CITY OF ALBUQUERQUE

**Re: The Boulders Phase 1 Pad Certification, Lot 72/ Lot 92 switch,
Engineer's Stamp date: 5-6-11 (B11/D001B)
Certification date: 03-13-12**

RONALD R. BOHANNAN P.E. #7888	THE BOULDERS PHASE 1		DRAWN BY DY
	RETAINING WALLS		DATE 05-06-11
	 TIERRA WEST, LLC 5571 MIDWAY PARK PLACE NE ALBUQUERQUE, NM 87109 (505)858-3100 tierrawestllc.com		2011005-SH01-02- GRE-PH1
			SHEET # 3
		JOB # 2011005

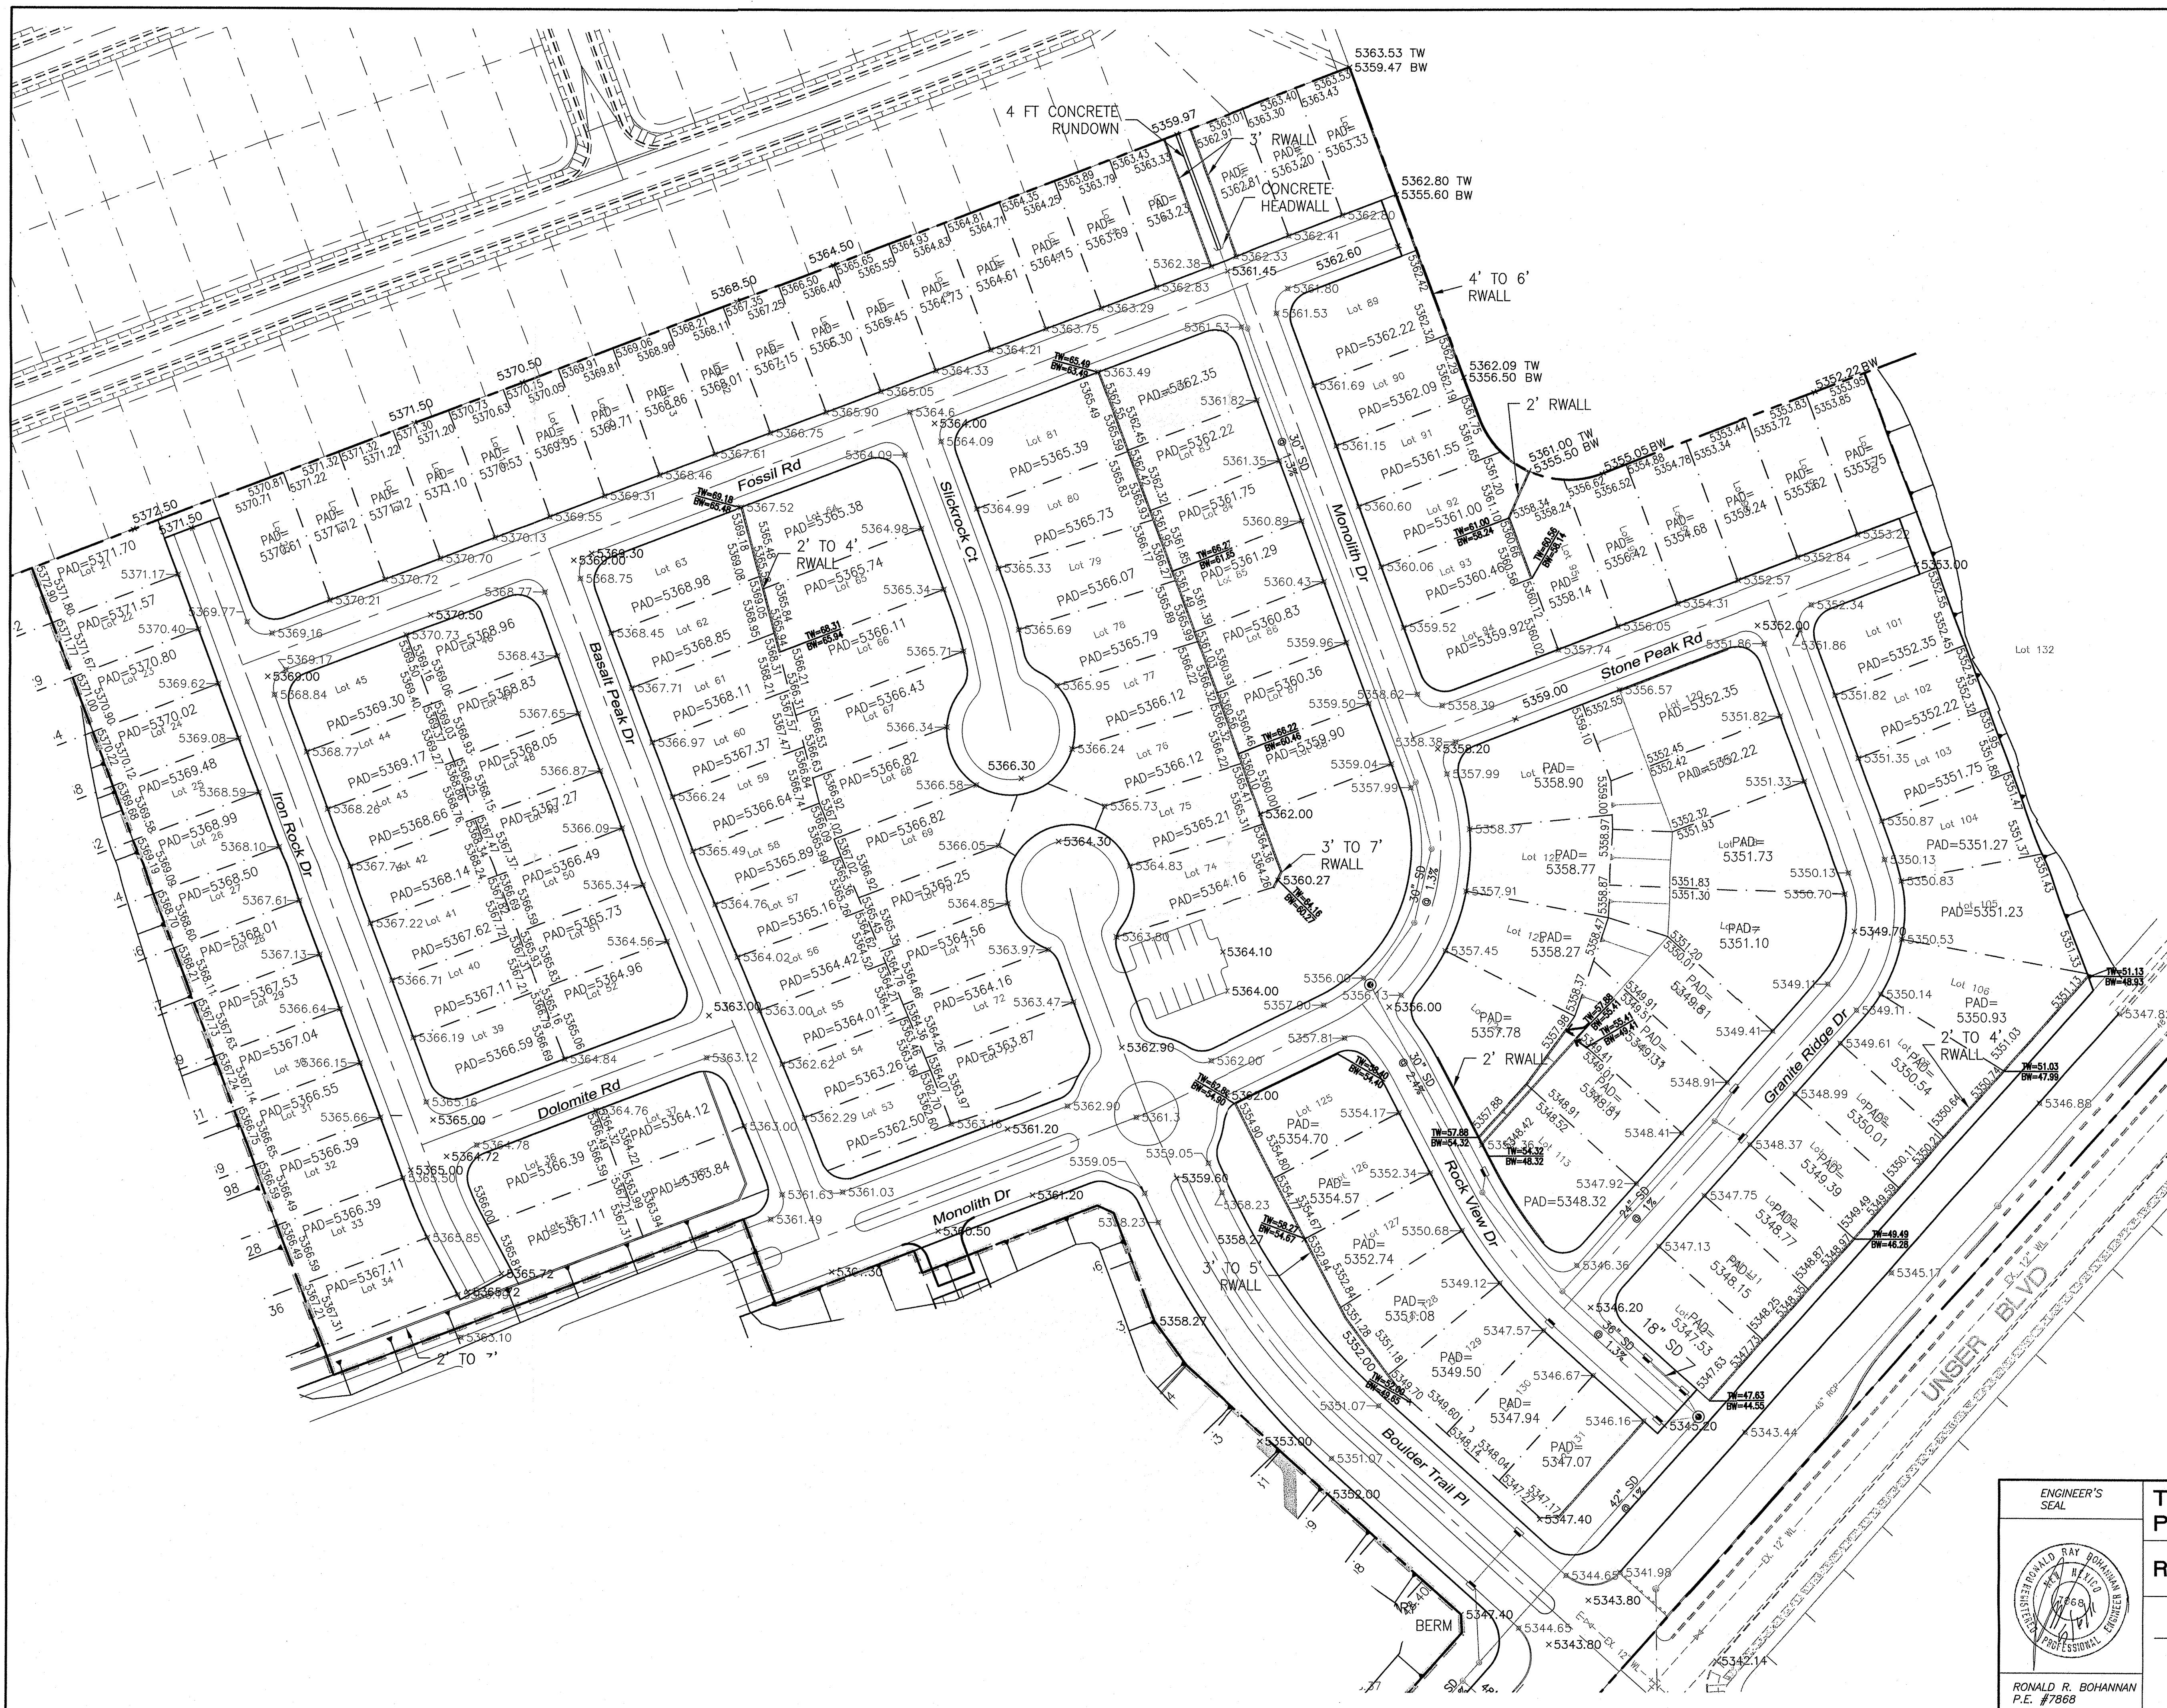
A pad certification requires an as-built grade elevation for all pads being certified, as-built elevations for the retaining walls abutting the rear property lines, and top of curb elevation. In the future please provide all addresses that the certification covers.
